City of Portland, Maine - Building or Use Permit Application
 389 Congress Street, 04101 Tel: (207) 874-8703, Fax: (207) 874-8716

Permit No: 10-0116	Issue Date:	CBL: 321 A004001
------------------------------	--------------------	----------------------------

Past Use: Trail	Proposed Use: Pedestrian Footbridge - build a 56' long x 4' wide pedestrian footbridge	Permit Fee: \$215.00	Cost of Work: \$12,000.00	CEO District: 5
Proposed Project Description: Build a 56' long x 4' wide pedestrian footbridge		FIRE DEPT: <input type="checkbox"/> Approved <input type="checkbox"/> Denied	INSPECTION: Use Group: Type	
		Signature: _____		Signature: _____
PEDESTRIAN ACTIVITIES DISTRICT (P.A.D.)				
Action <input type="checkbox"/> Approved <input type="checkbox"/> Approved w/Condition <input type="checkbox"/> Denied				
Signature: _____ Date: _____

Green nylon-coated chain link fence

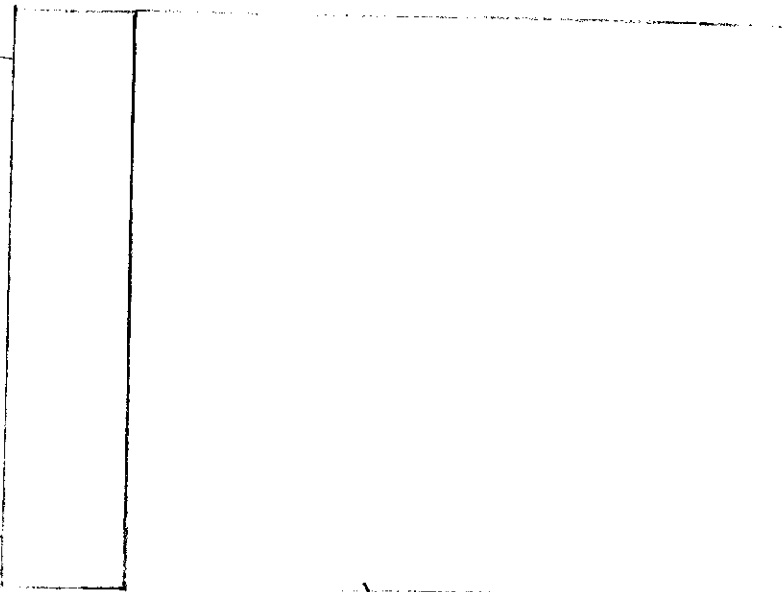
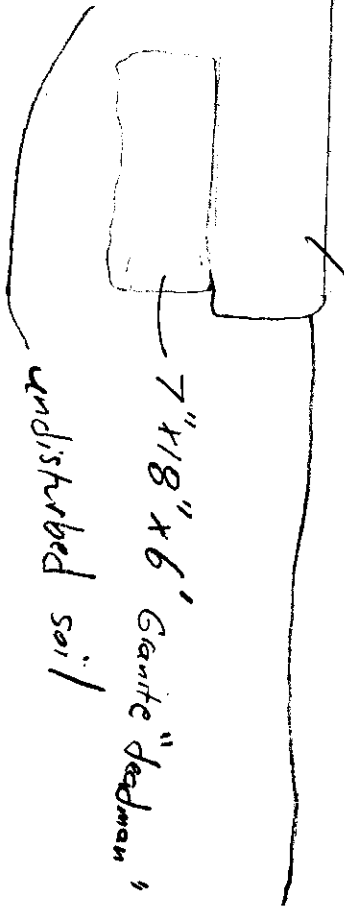
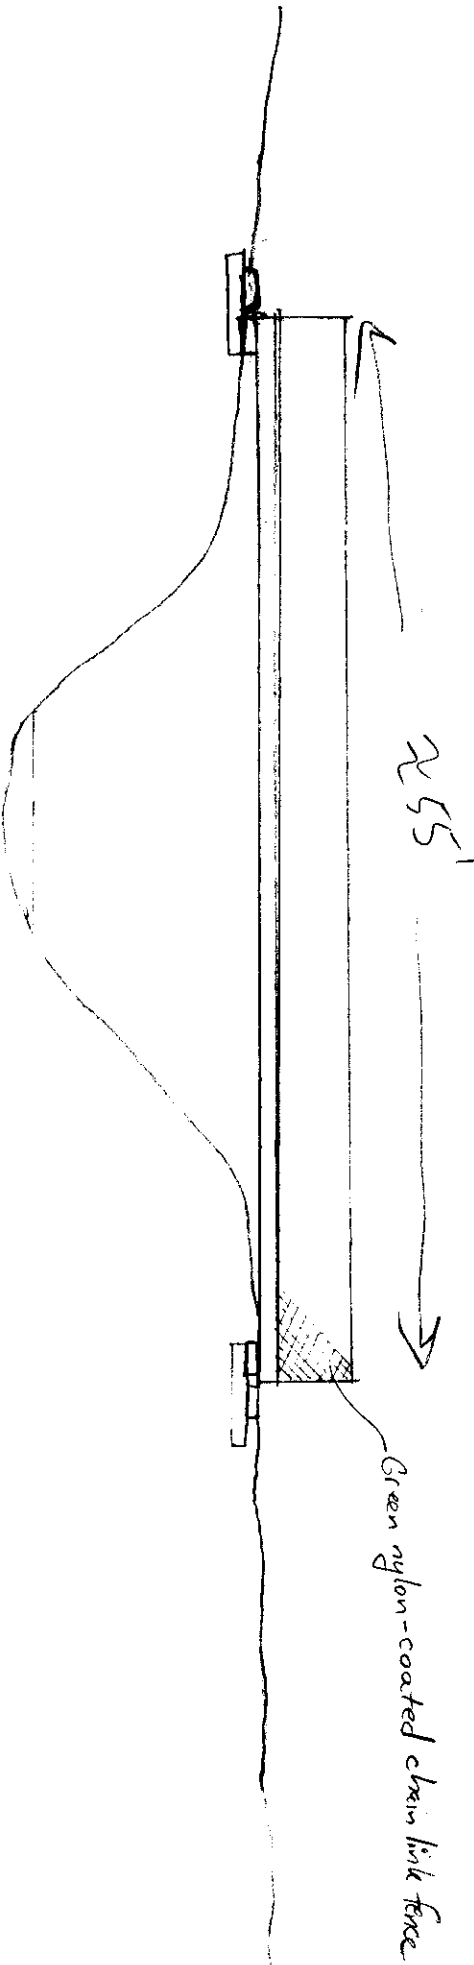
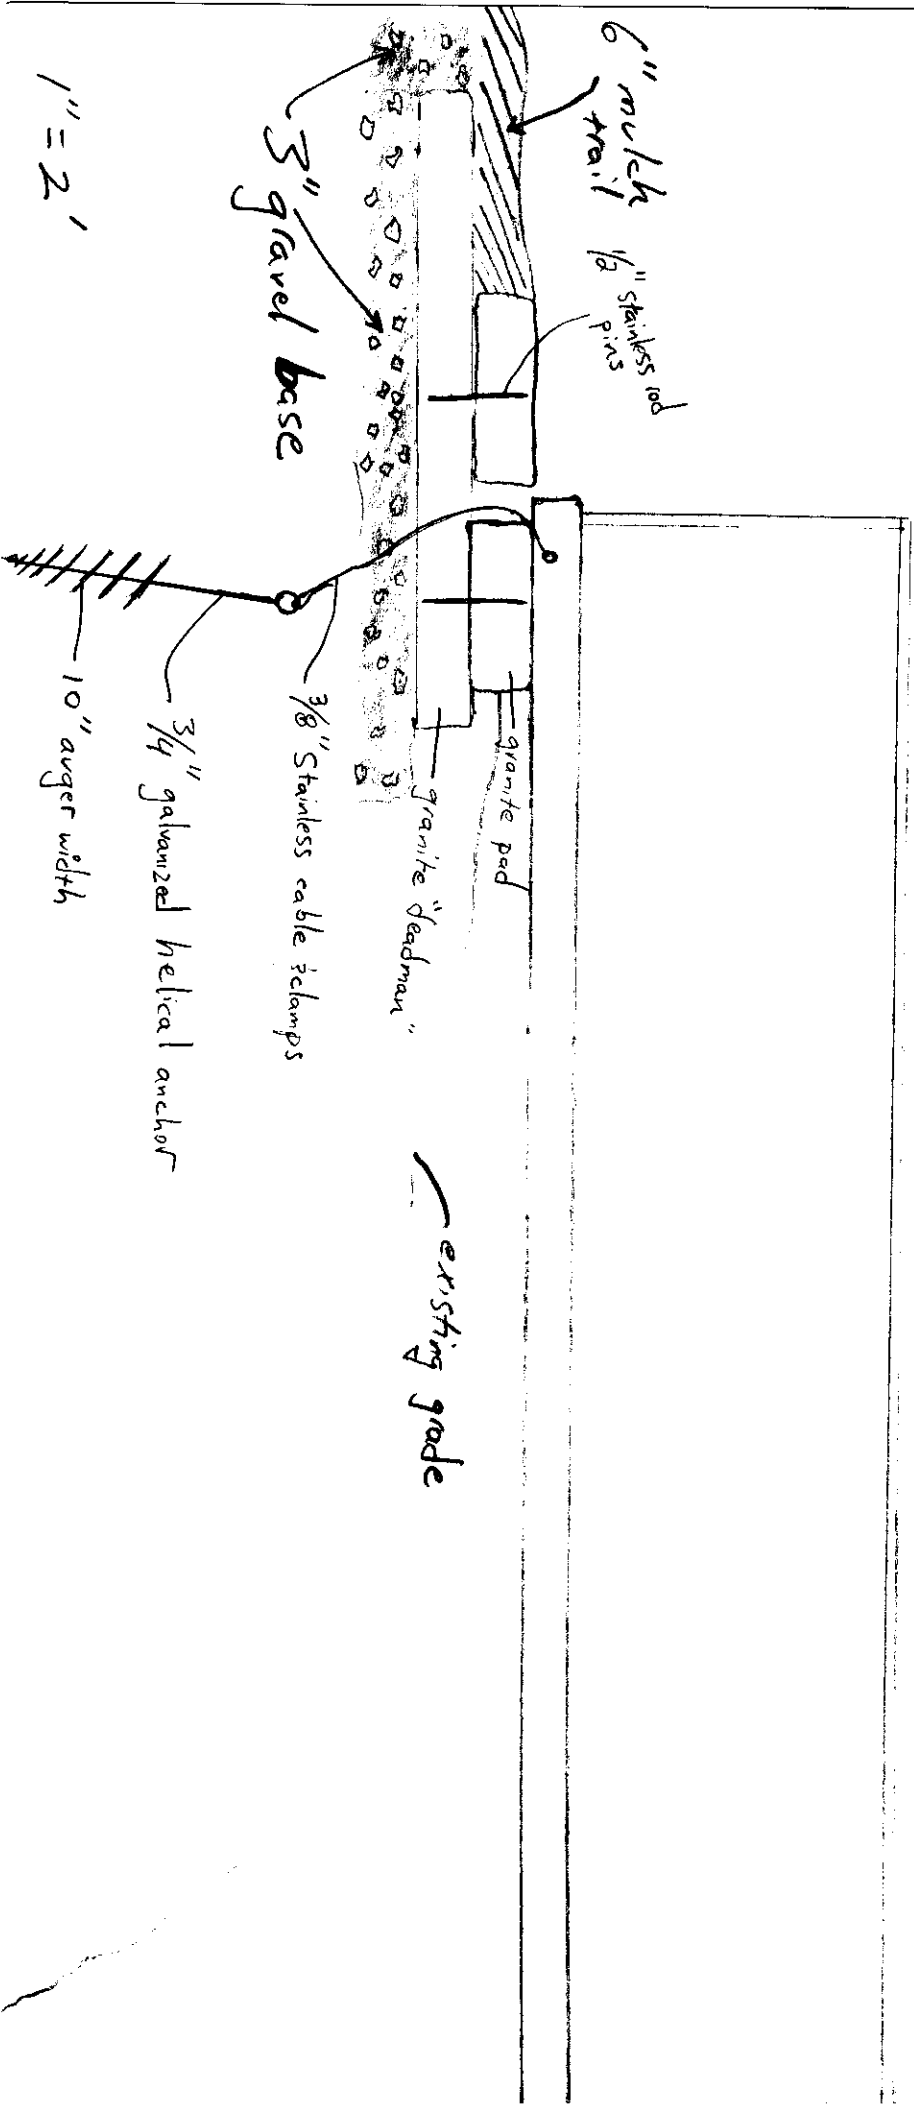
Comments:
2/10/2010-jmb: Left vmsg for Jaime P for verification of chainlink fence on guardrail and fabricator information.
2/12/2010-jmb: Returned Jaime P. Call, he will get the contact info for the fabricator and the fencing will be installed to minimize spaces less than 4".
2/12/2010-jmb: Left msg for Jim Griffith at Dock Works, Inc, the fabricator shop to see if it is registered.
2/18/2010-jmb: Spoke to Jim G., they are a certified welding shop with over 20 years experience, he gave me the number to contact Barney B. The engineer.
2/19/2010-jmb: Spoke with Barney about the fabrication process, he says the design exceeds industry standards and the SI would cover checking the license of the certified welder and the longevity of the shop. Also spoke with Dale Dyer of Custom Float Services who will be assisting PT in the location and anchoring of the walkway. He has checked the soils and is confident the silty clay is optimum for the helical anchors. He doesn't anticipate much movement over time and sees maintenance as minor over several years. Also there is no erosion at the location of the walkway bearing.
